LSC Responses to TIS Redline Comments

Sterling Recycling Facility Transportation Memorandum PCD File No.: PPR2241 (LSC #S224330) August 24, 2023

RE: Sterling Recycling Facility
Transportation Memorandum
El Paso County, Colorado
PCD FILE NO. **17PR2241**
LSC #S224330

SITE DEVELOPMENT PLAN

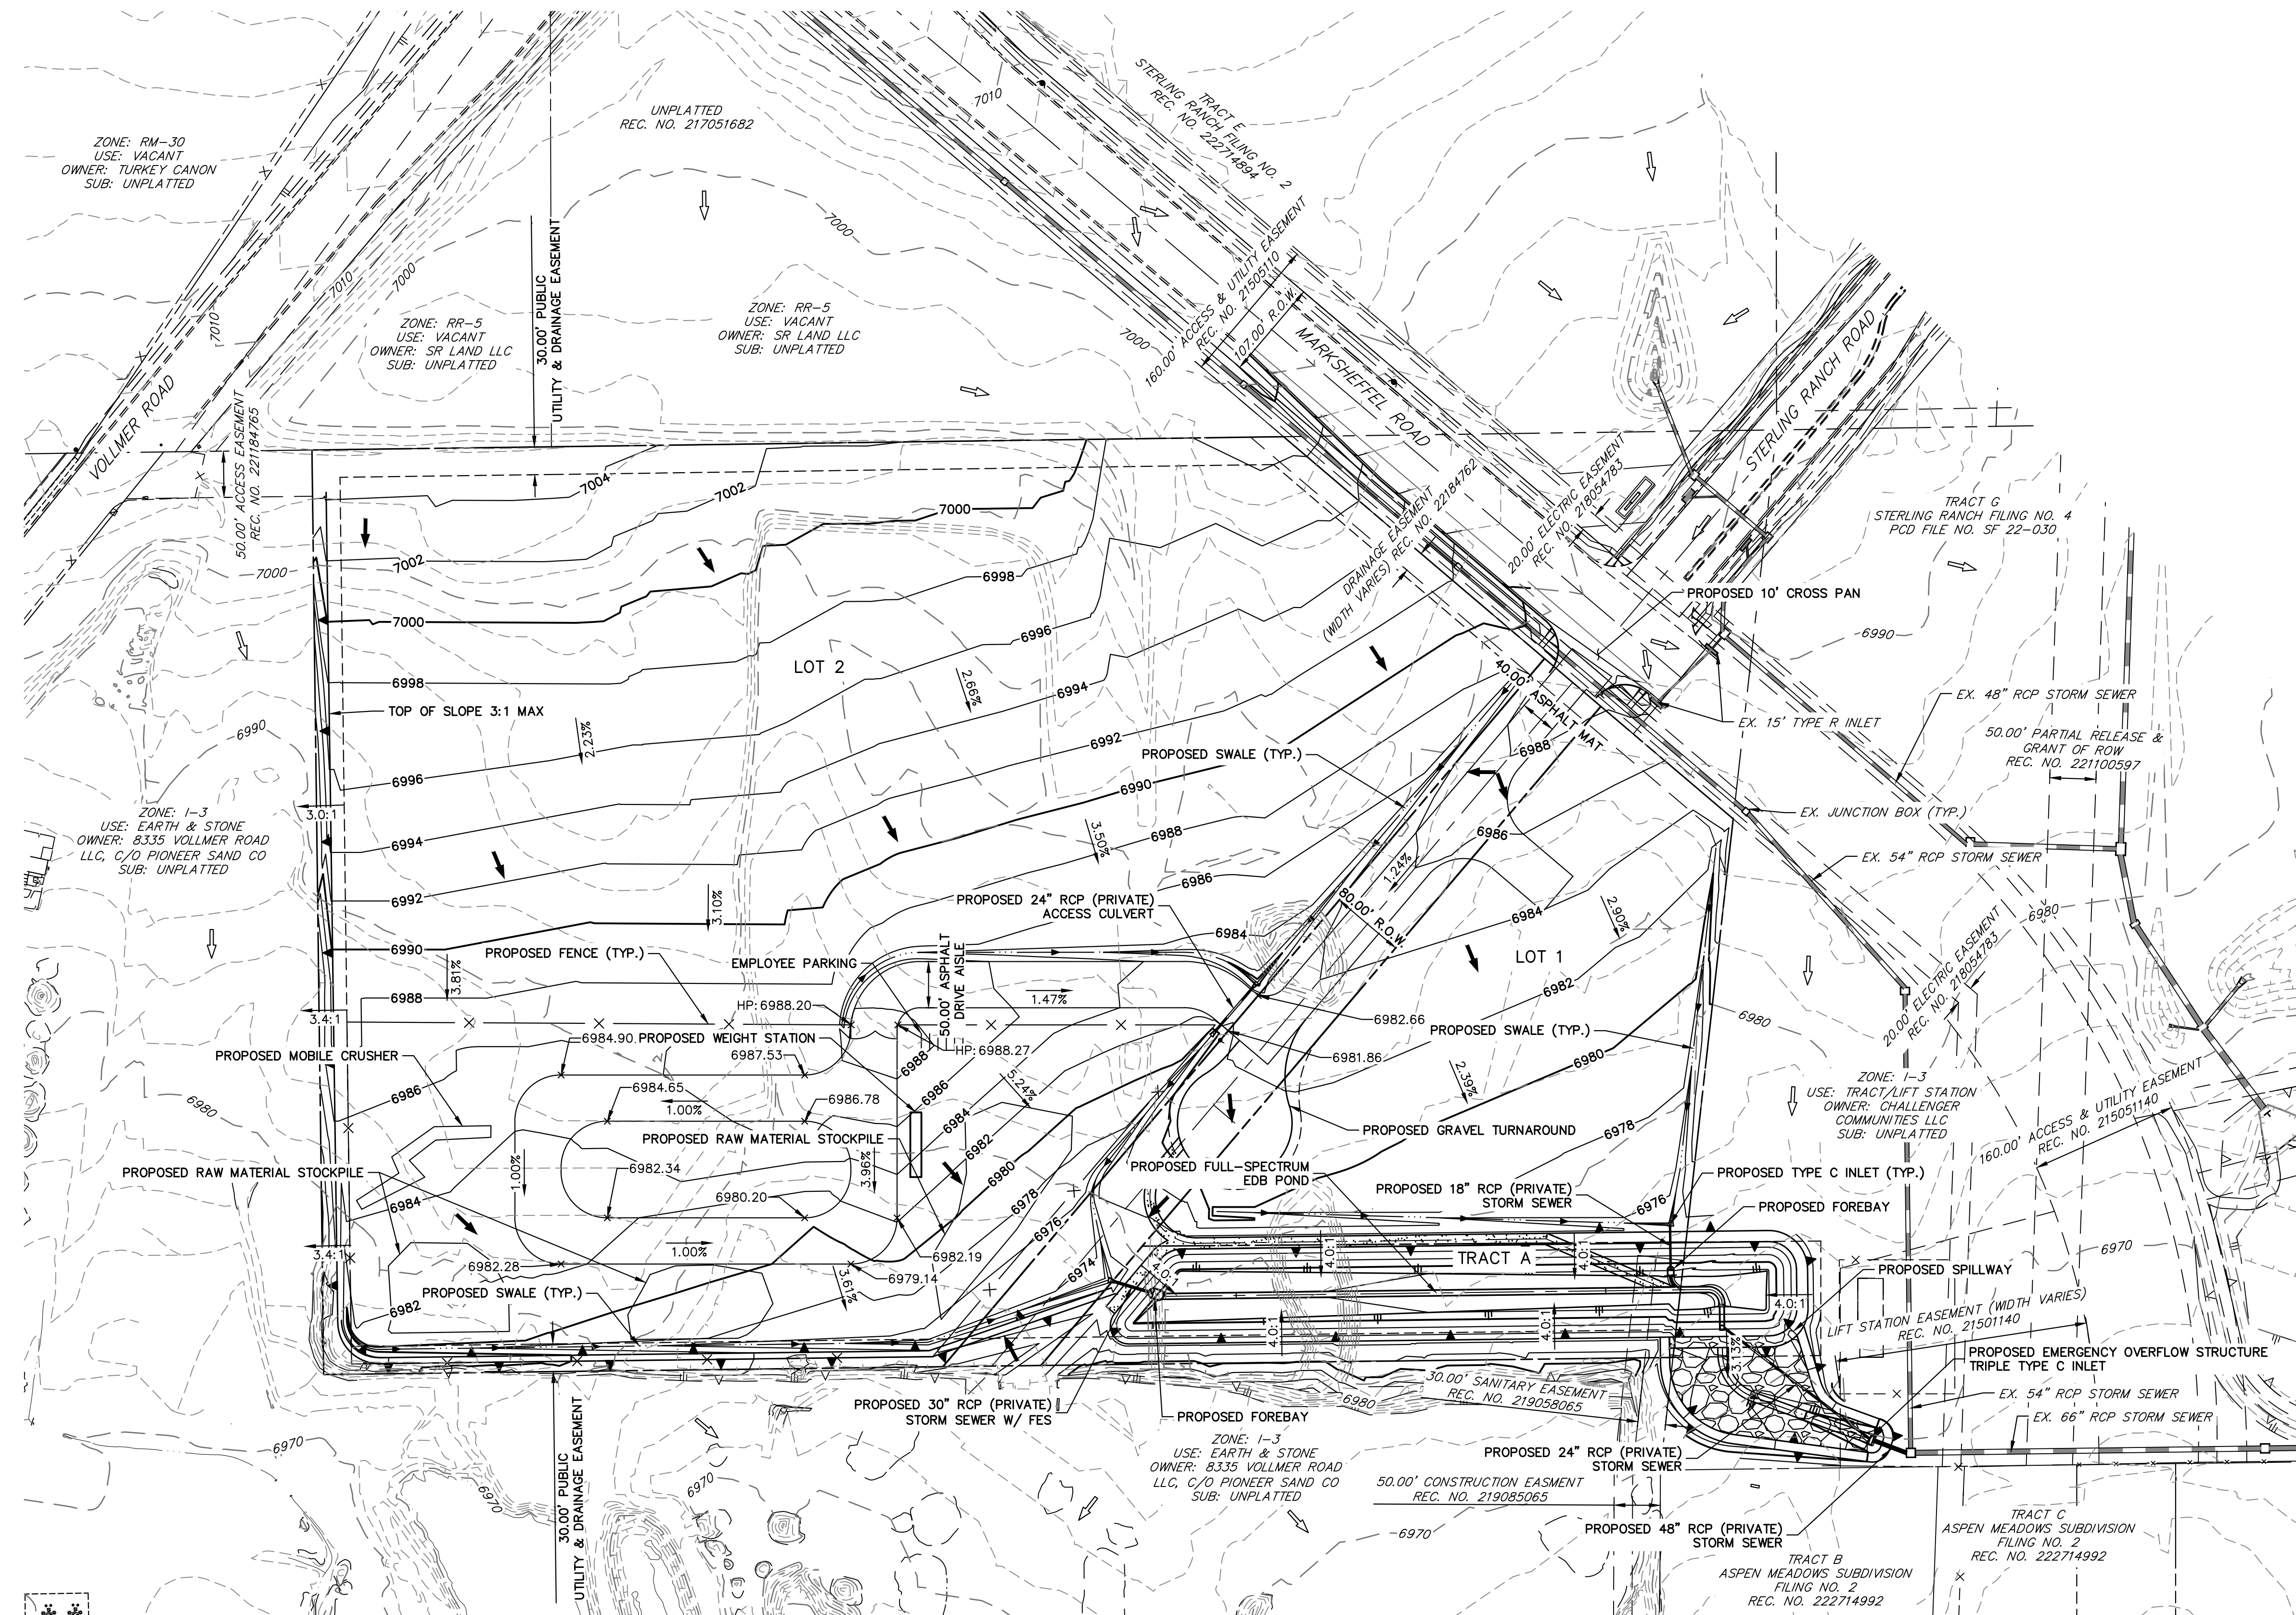
Please address access spacing for LOT #1 and proximity to Marksheffel along Sterling Ranch. Dependant on lot use type and traffic generation does this spacing meet requirement or should the access be moved further south close to the temp Cul-de-sac and a possible full movement with Lot #2. Spacing is only ~140ft and inside the transition lane area for EB and SB right turn onto Marksheffel. Left turns into LOT #1 do not seem to be addressed

↩ Author: kdferrin Subject: Sticky Note Date: 3/19/2024 3:11:04 PM
LSC Response: This access has been relocated as requested.
